THE PADDINGTON SOCIETY Inc.
For Community and Heritage
Est 1964

31 August 2016

Section 75W Amendment to MP10_0016, Scottish Hospital Paddington

Approved Landscape Plan SK-09 – Showing Trees to be removed and retained in original approval

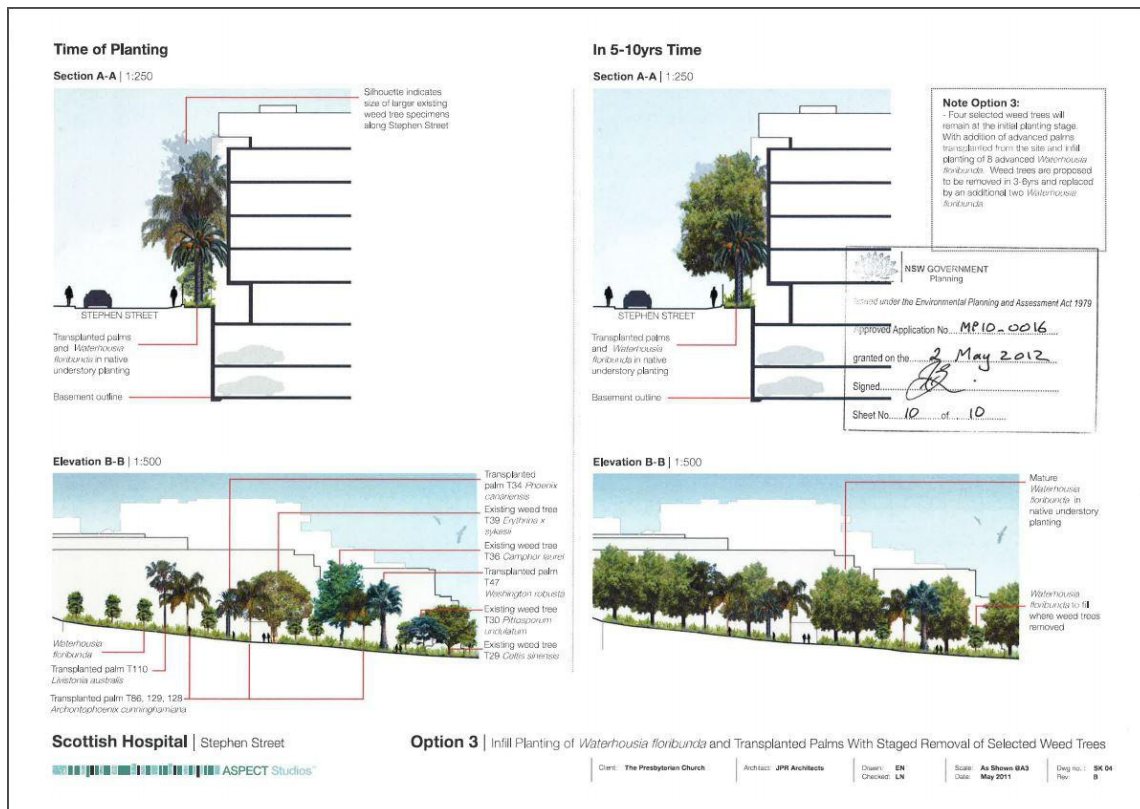
Tree 5 is a mature 18m Camphor Laurel currently classified with Retention Value B. It is one of the largest remaining trees on the site. The Department and the PAC considered it of sufficient significance to be not only retained but listed among trees specified to be subject to special protection measures in the construction period (Approval document, Condition C5). The reasons given by the arborist are of 3 kinds:

Reasons related to 1 are matters of convenience for the builder and should not override the destruction of trees identified as deserving retention.

Reasons related to 2 include that it will reduce competition for and improve views of Tree 6, a Weeping Lilly Pilly which similar to Tree 5 has been identified as of sufficient significance to be retained and protected in the construction period. The arborist's report has not explored alternatives to removal of Tree 5, such as pruning of either or both trees and measures to improve water retention and soil nutrition, to the extent that these problems are serious.

Trees 127 (Port Jackson Fig) and 133 (Magenta Lilly Pilly) have previously been identified for retention. According to the arborist, both these trees are threatened by construction works unless Tree 5 is removed. This recommendation makes a nonsense of the original recommendation for retention of all these trees (among the minority of then existing trees to be preserved). Clearly the real reason is convenience for construction. All these trees should be retained.

Tree 130 is a 16m Sydney Red Gum (Angophora) rated as of Retention Value A. This tree species is protected under the Woollahra Tree Preservation Order. The reasons given for its removal all relate to improved convenience in the construction phase, apparently exacerbated by an error in the surveyor's plan putting the tree's trunk "marginally" further from the proposed driveway ramp to the basement than it actually is, and giving rise to the possibility that the tree will be undermined in construction of the proposed ramp.

There is no evidence that any alternatives to removal of this significant tree have been considered. In view of its high retention value, Tree 130 should be preserved even if this entails modifications to the construction plan. In view of the "marginal" nature of the survey error, this should be feasible.

For the reasons stated above, The Paddington Society requests that Amendments 3, 4 and 5 relating to changes in the landscape plan be refused. We also ask that the unapproved removal of the replacement for Tree 18 be rectified by the planting of a similar tree as close to its original site as possible.
